Application no: 21/02496/DISC

Location: Land to The South And Adj To, South Side, Steeple Aston

Lead Local Flood Authority

Objection to Discharge of Condition 5

Test Pit SP2 T1

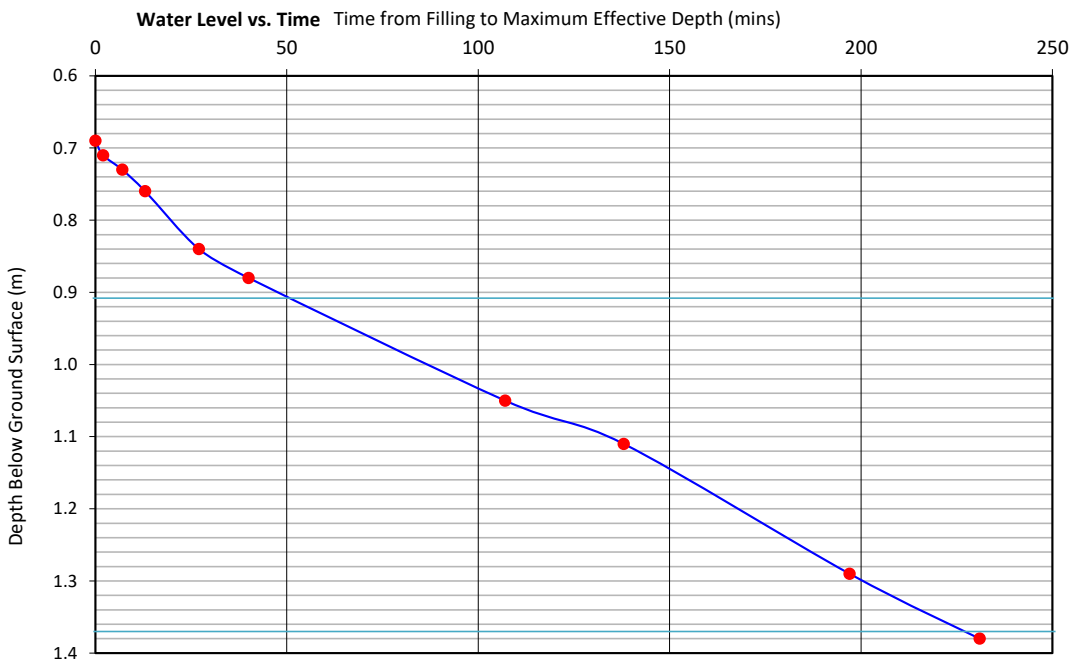
The infiltration test results shows SP2 T1 (page 21), however on plan this has not been identified. Also ST2 T1 the infiltration result is missing. Can you please clarify and update the infiltration report accordingly.
